Department of Planning, Industry and Environment
 Social and Infrastructure Assessments
 (Planning and Assessment)

**Re: State Significant Development - SSD 10391 – New Liverpool Primary School
 (18 Forbes Street, Liverpool NSW 2170)**

Thank you for your correspondence dated 25 June 2021 requesting Liverpool City Council's comment on the State Significant Development for the construction of a new Liverpool Primary School at 18 Forbes Street, Liverpool.

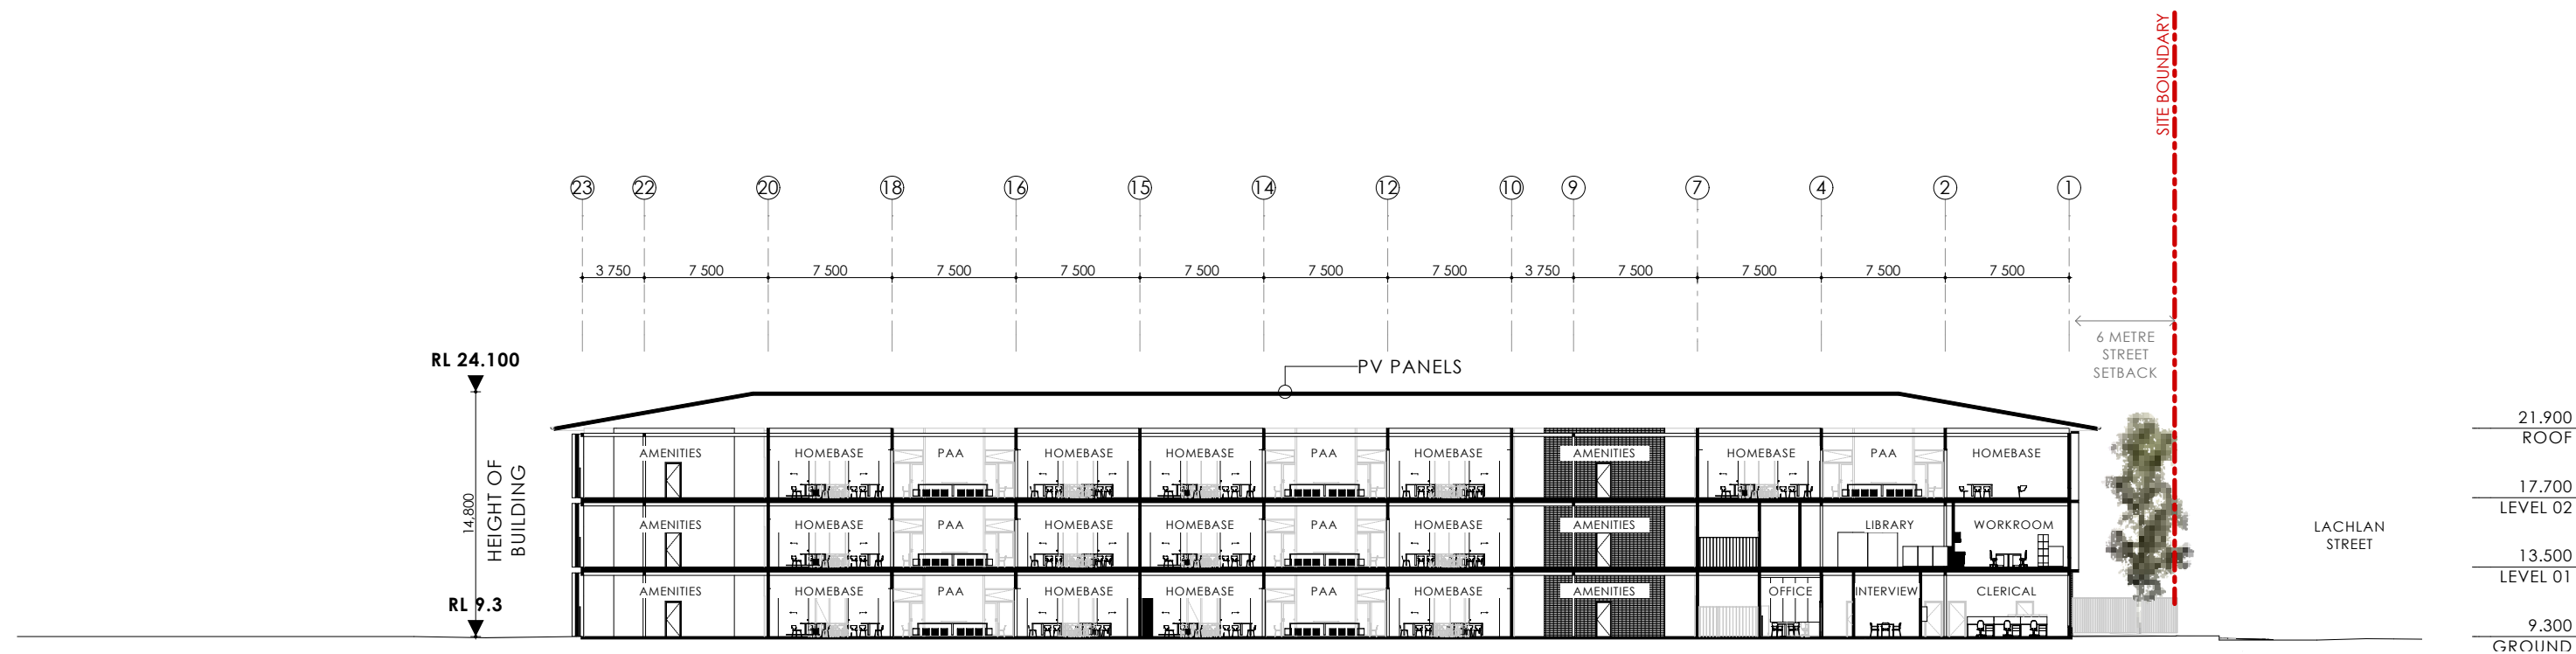
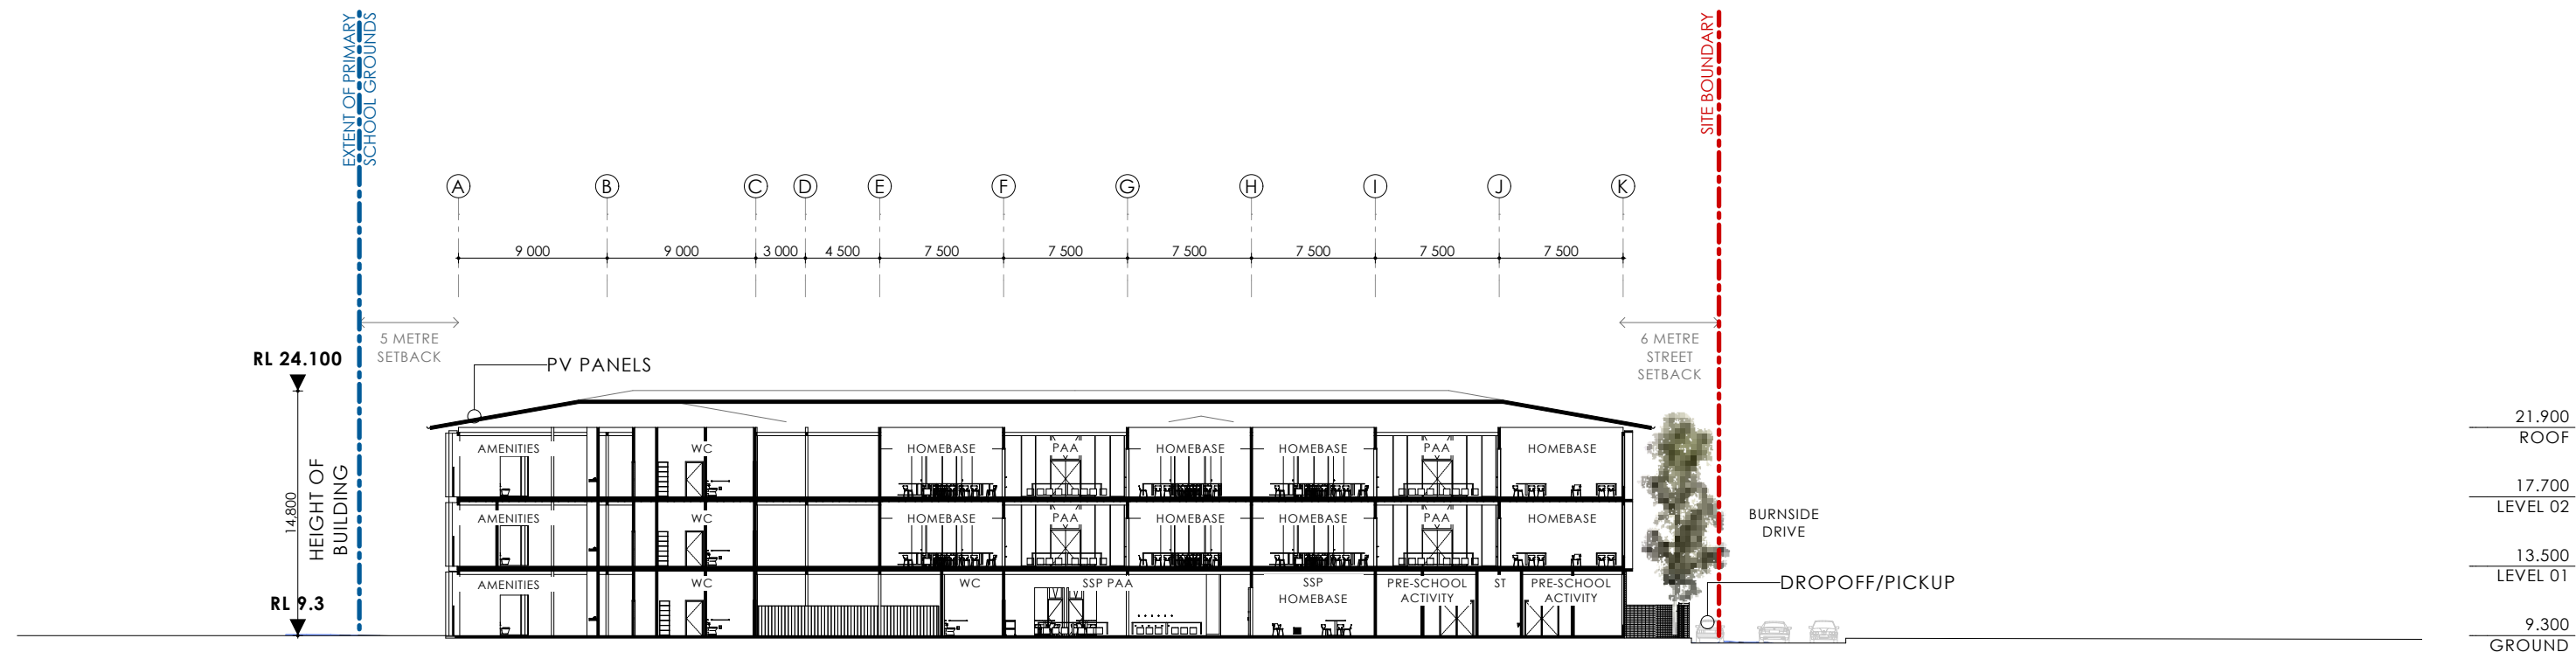
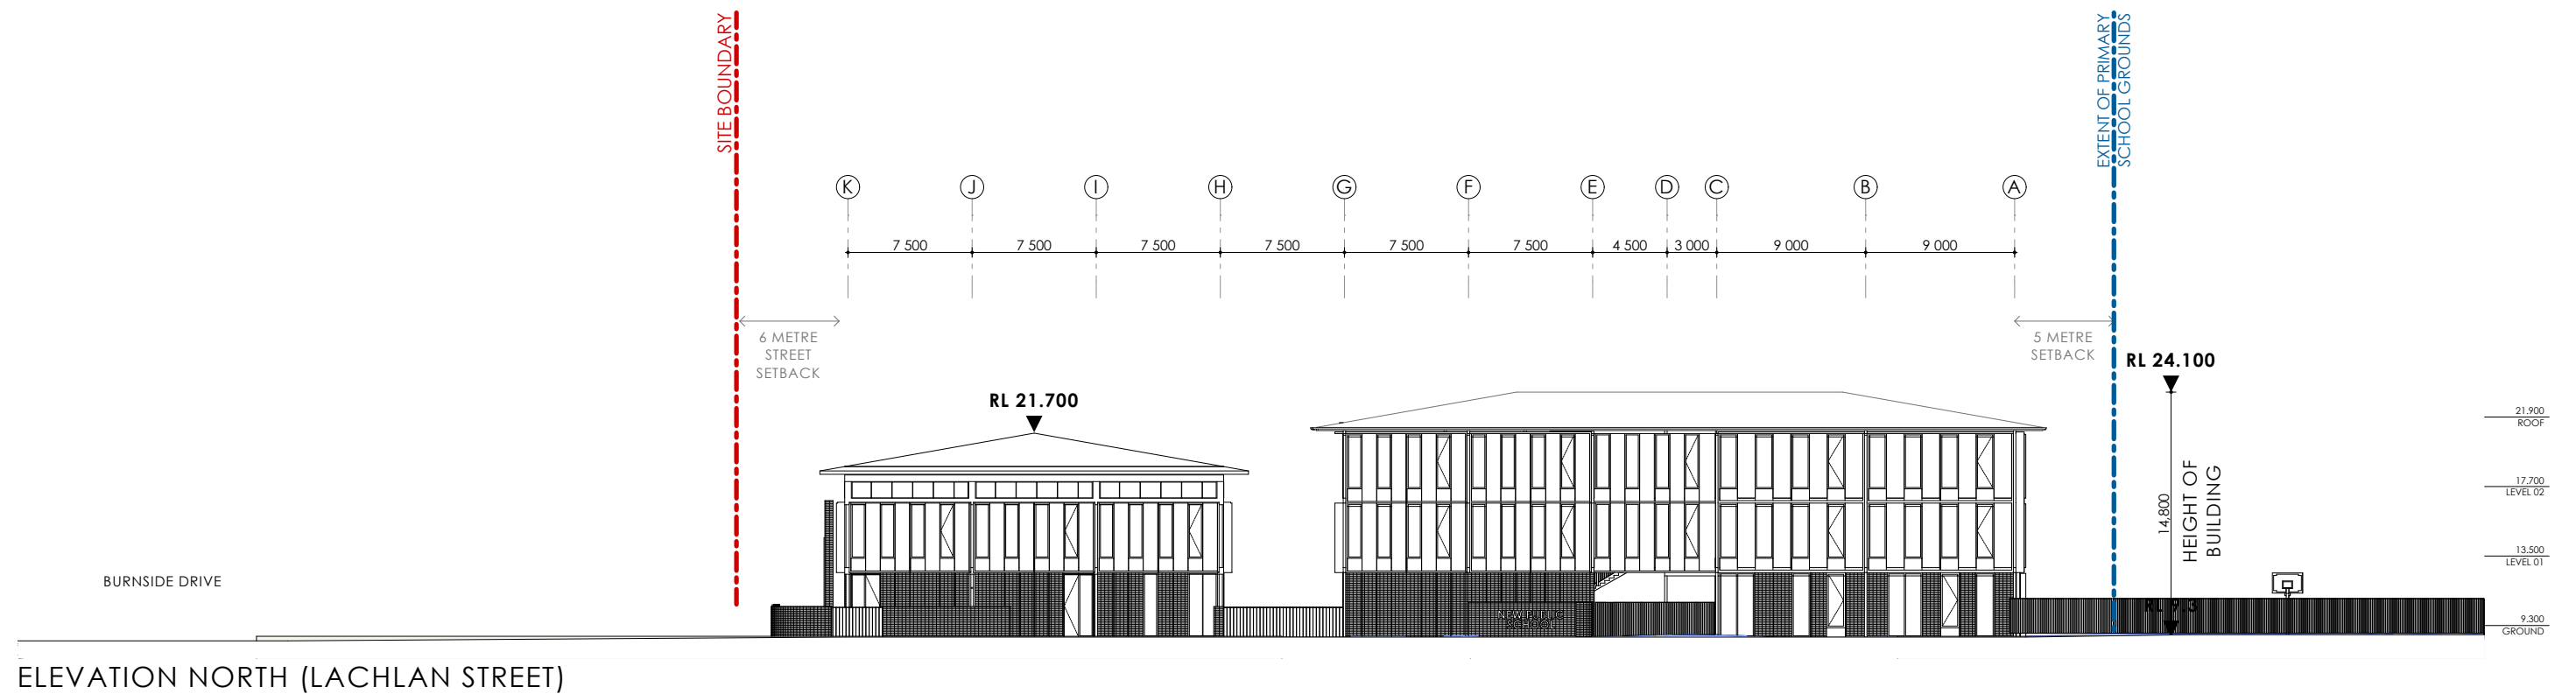
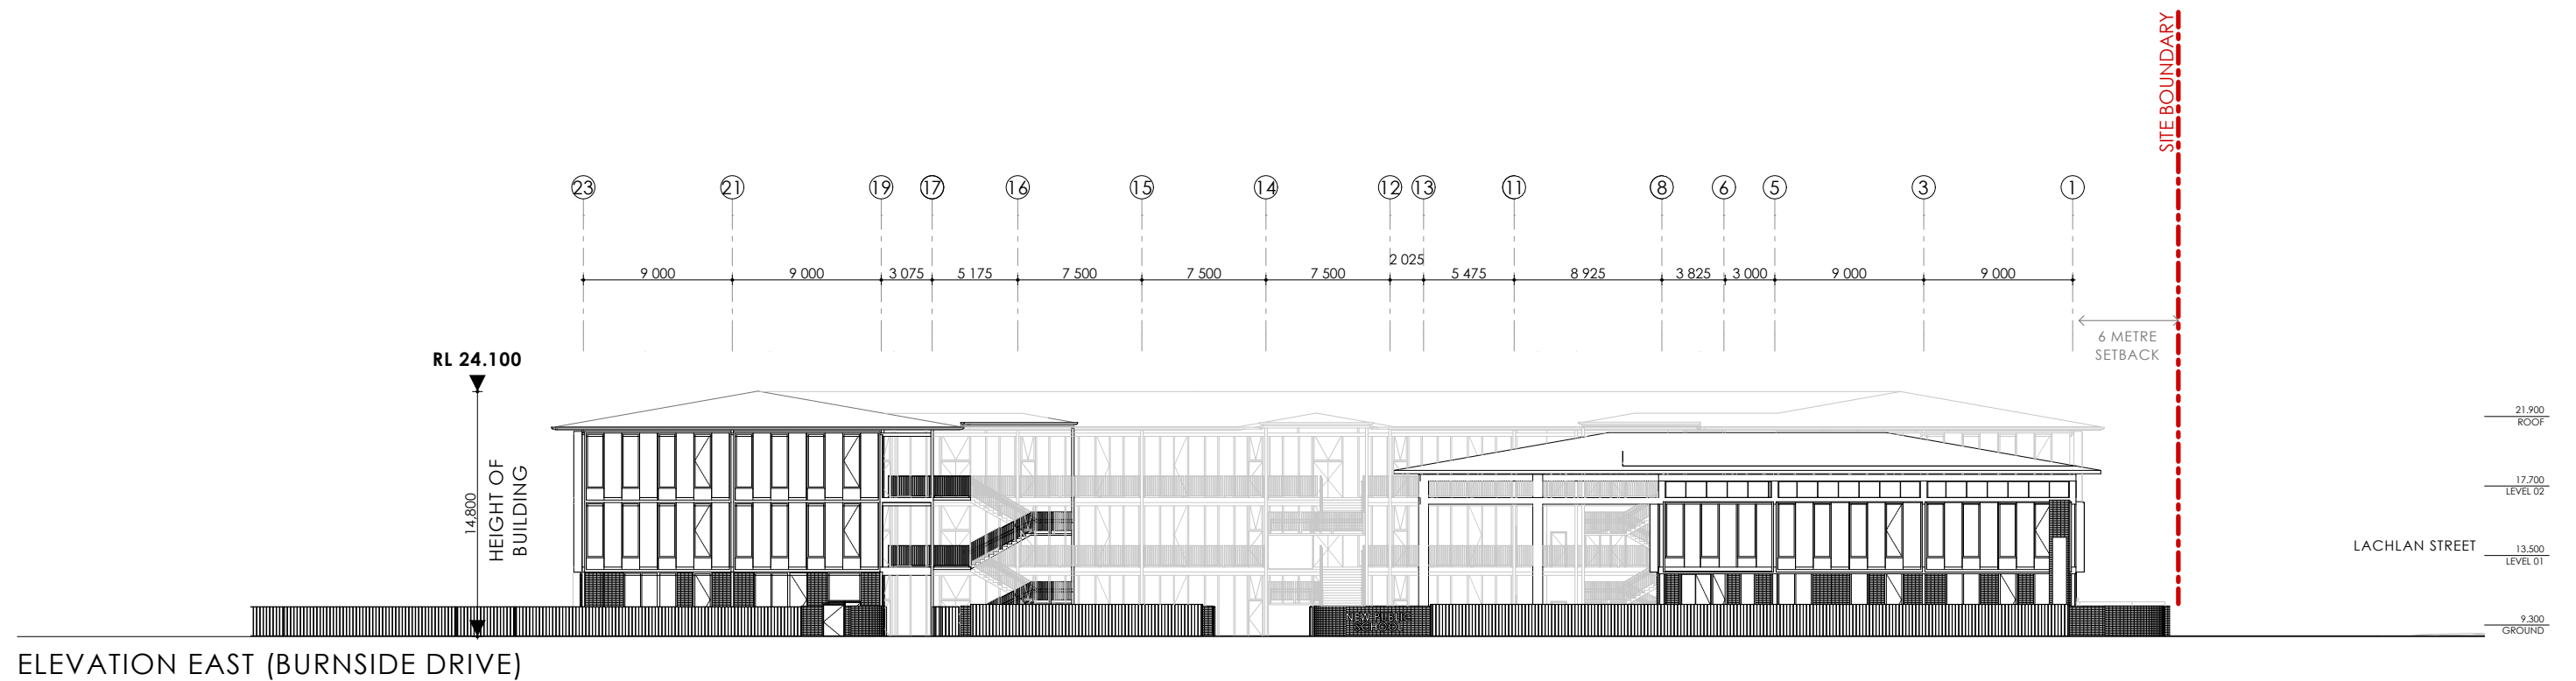
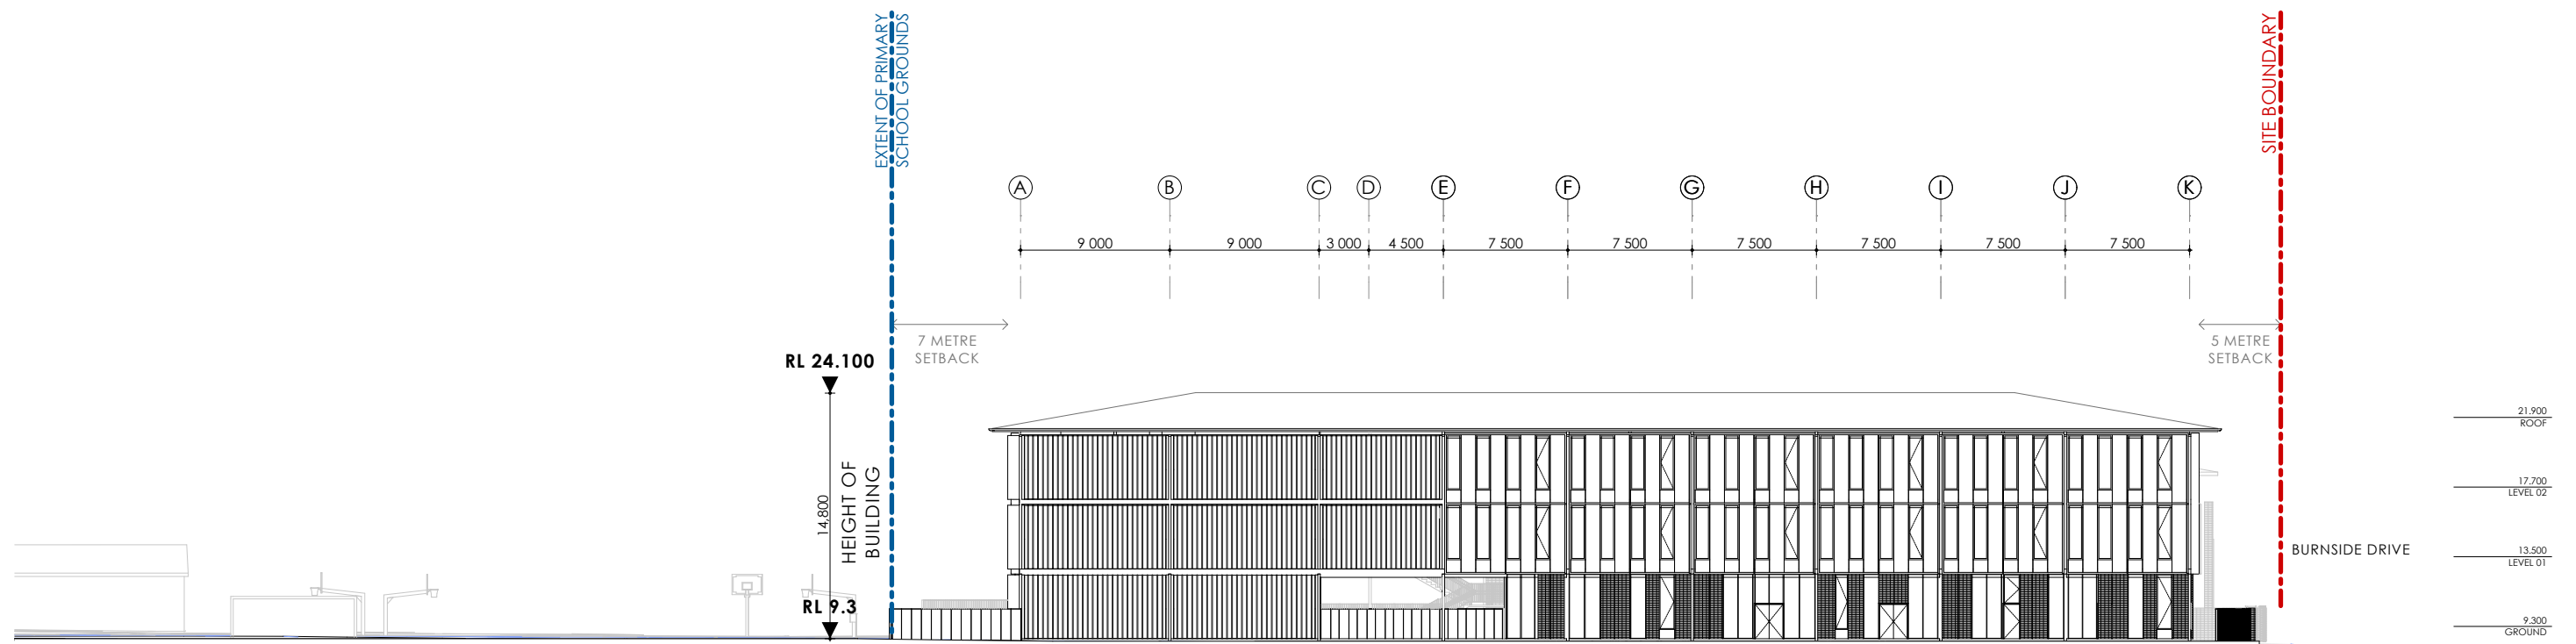
The roof form identified is quite basic. Whilst cost effectiveness is a key consideration, extending larger eaves overhangs along the western, northern, and eastern sides of all buildings can serve to reduce the ongoing operational costs, particularly in summer months where Liverpool suffers from urban heat island effects.
